PLANNING CONSULTATION RESPONSE

Application No	2026/2044
Proposal	Demolition of existing building and septic tank and erection of new single storey community and sports pavilion, reconfiguration of parking, new landscaping and other associated works.
Address	Rabbit Ings Country Park, Lund Hill Lane, Royston, Barnsley, S71 4BB
Date of Consultation Reply	08/07/2026
Consultee	Claire Wilson, Planning Ecologist

TITLE
Proposed Site Plan

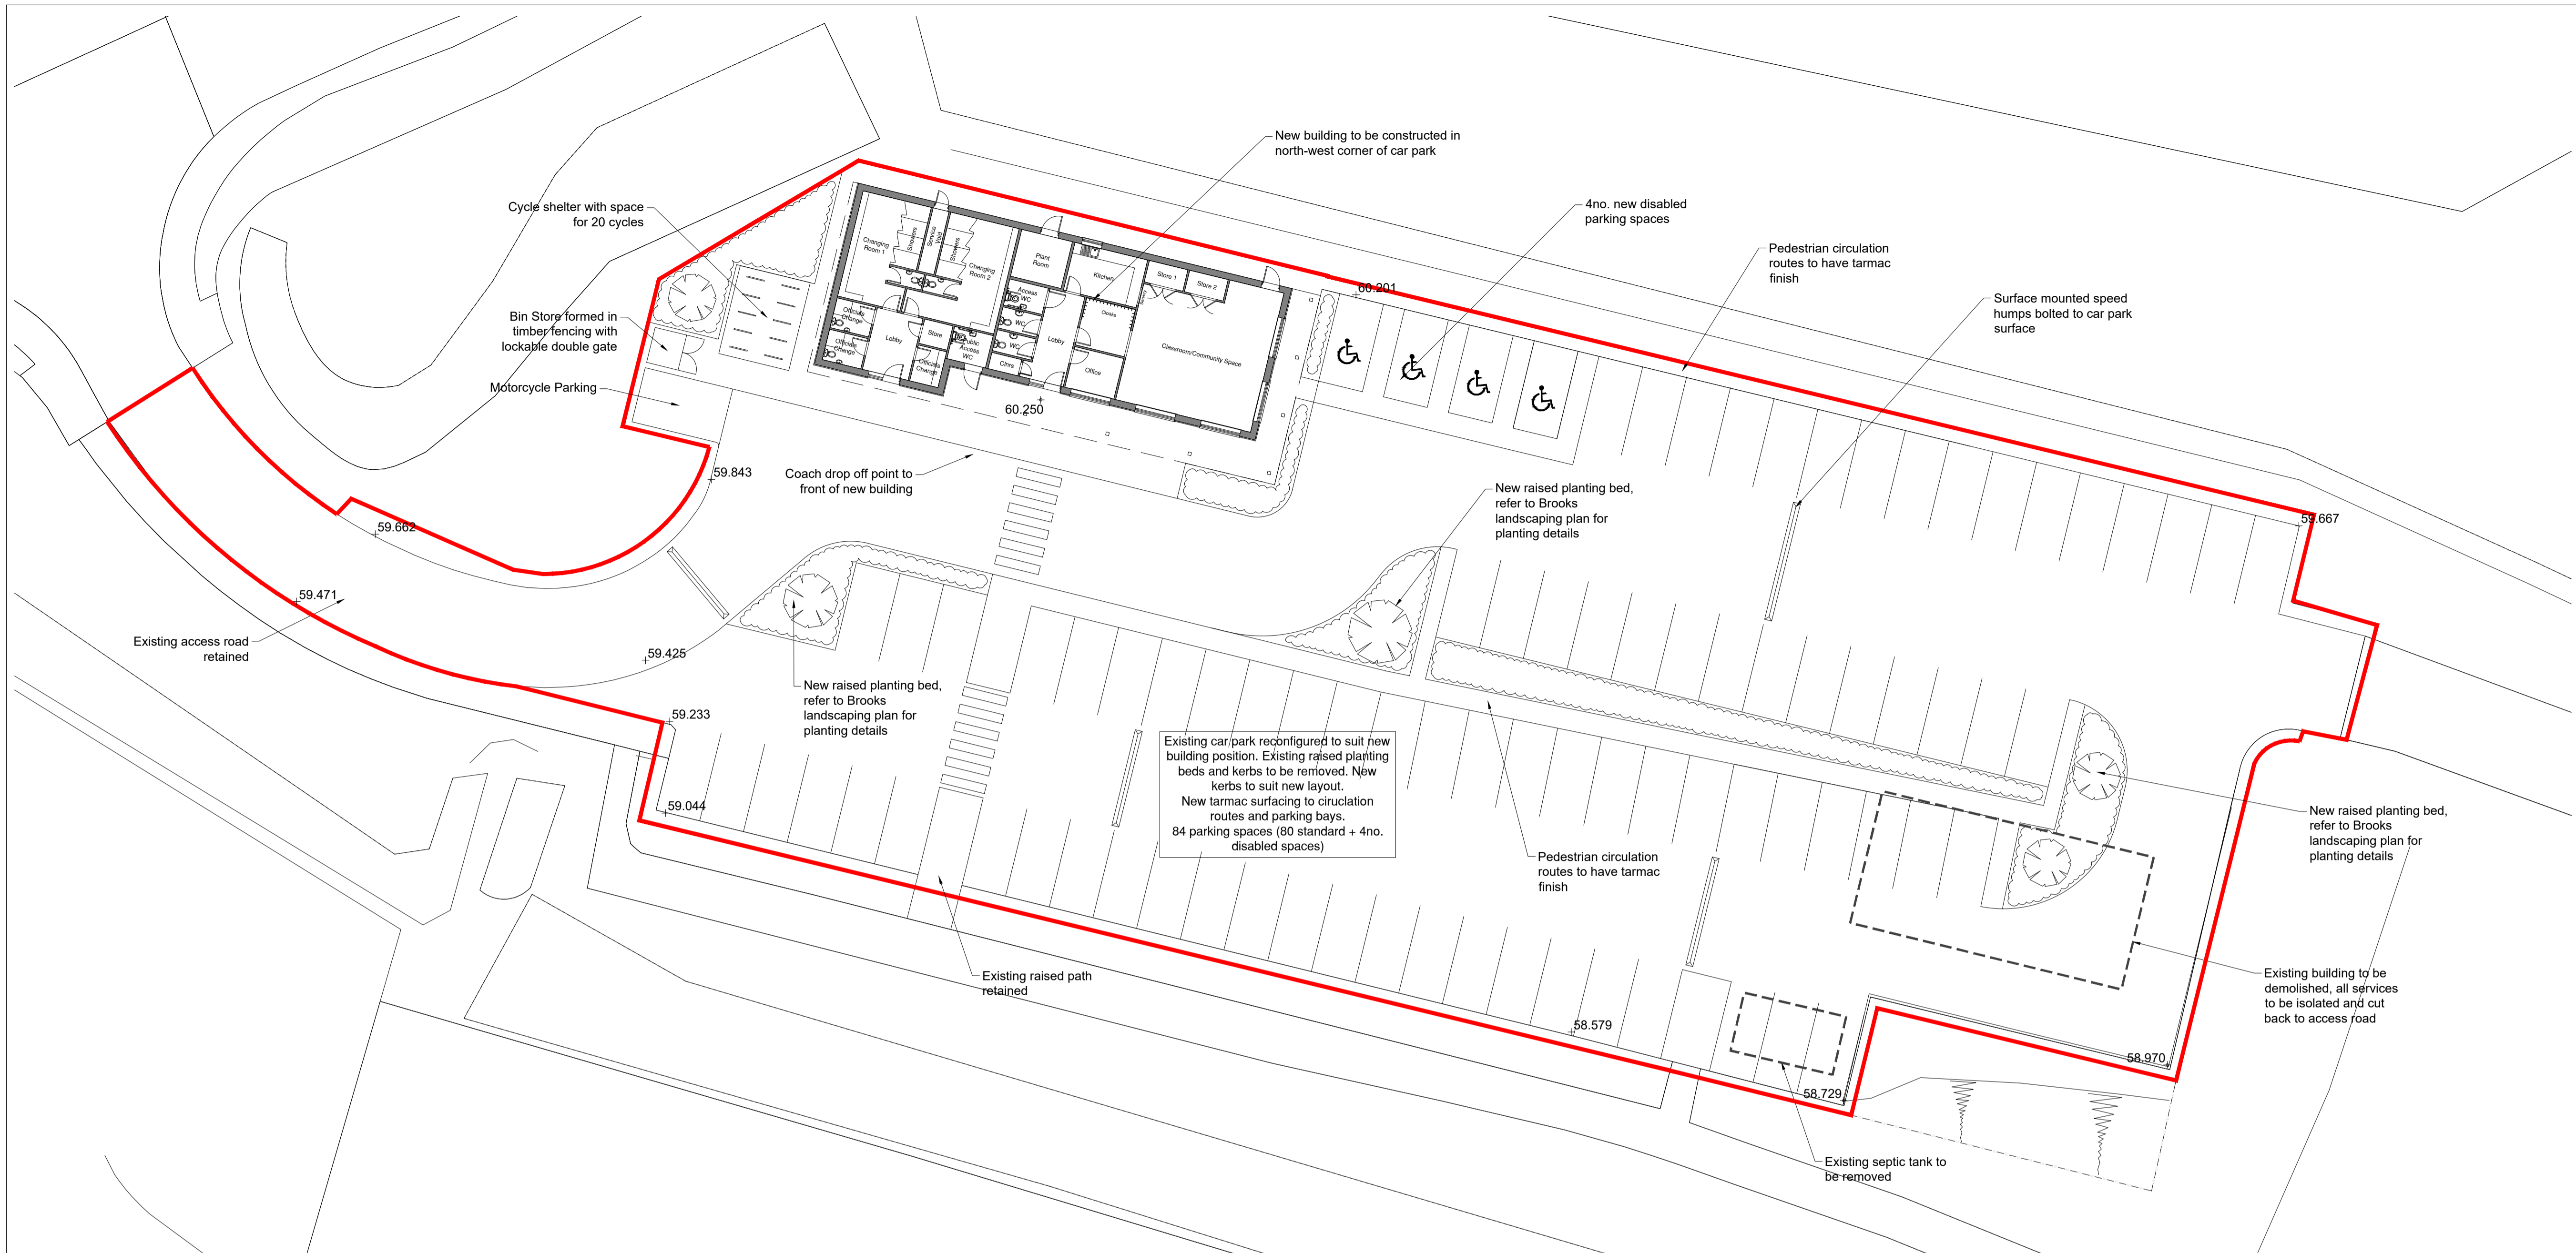
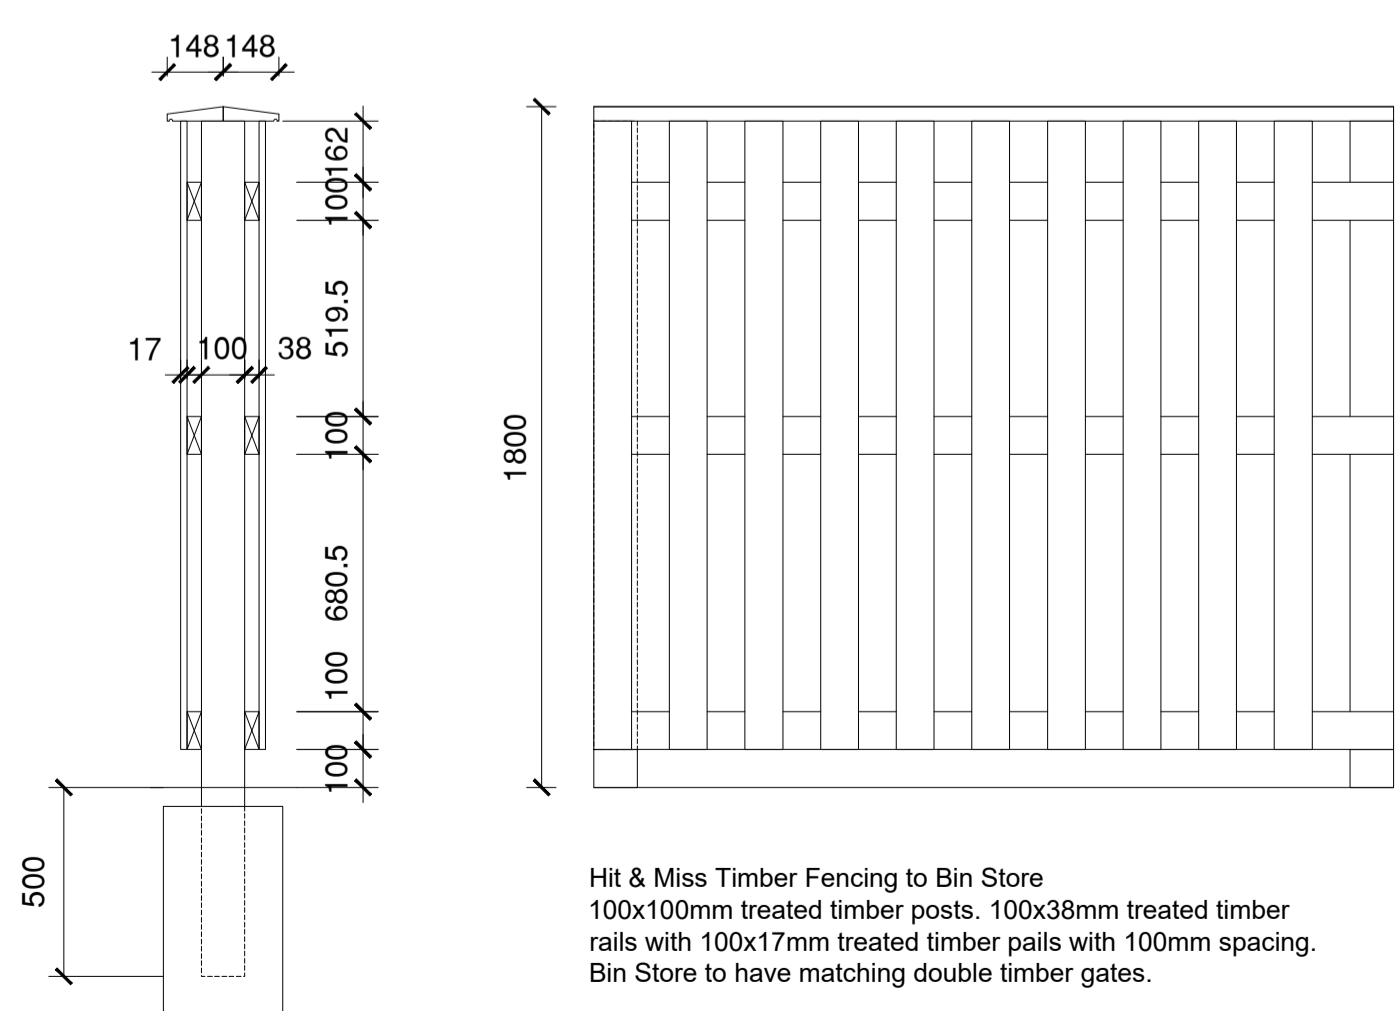
I note within the landscaping plans that cycle shelters and bin stores are proposed. There is potential to incorporate green roofs onto these features to help achieve a minimum 10% gain. This could also be considered within the new building on site. However, if it is intended to purchase off-site biodiversity units to meet the developments BNG requirements, these would ideally be purchased within the Barnsley LPA boundary, where possible.
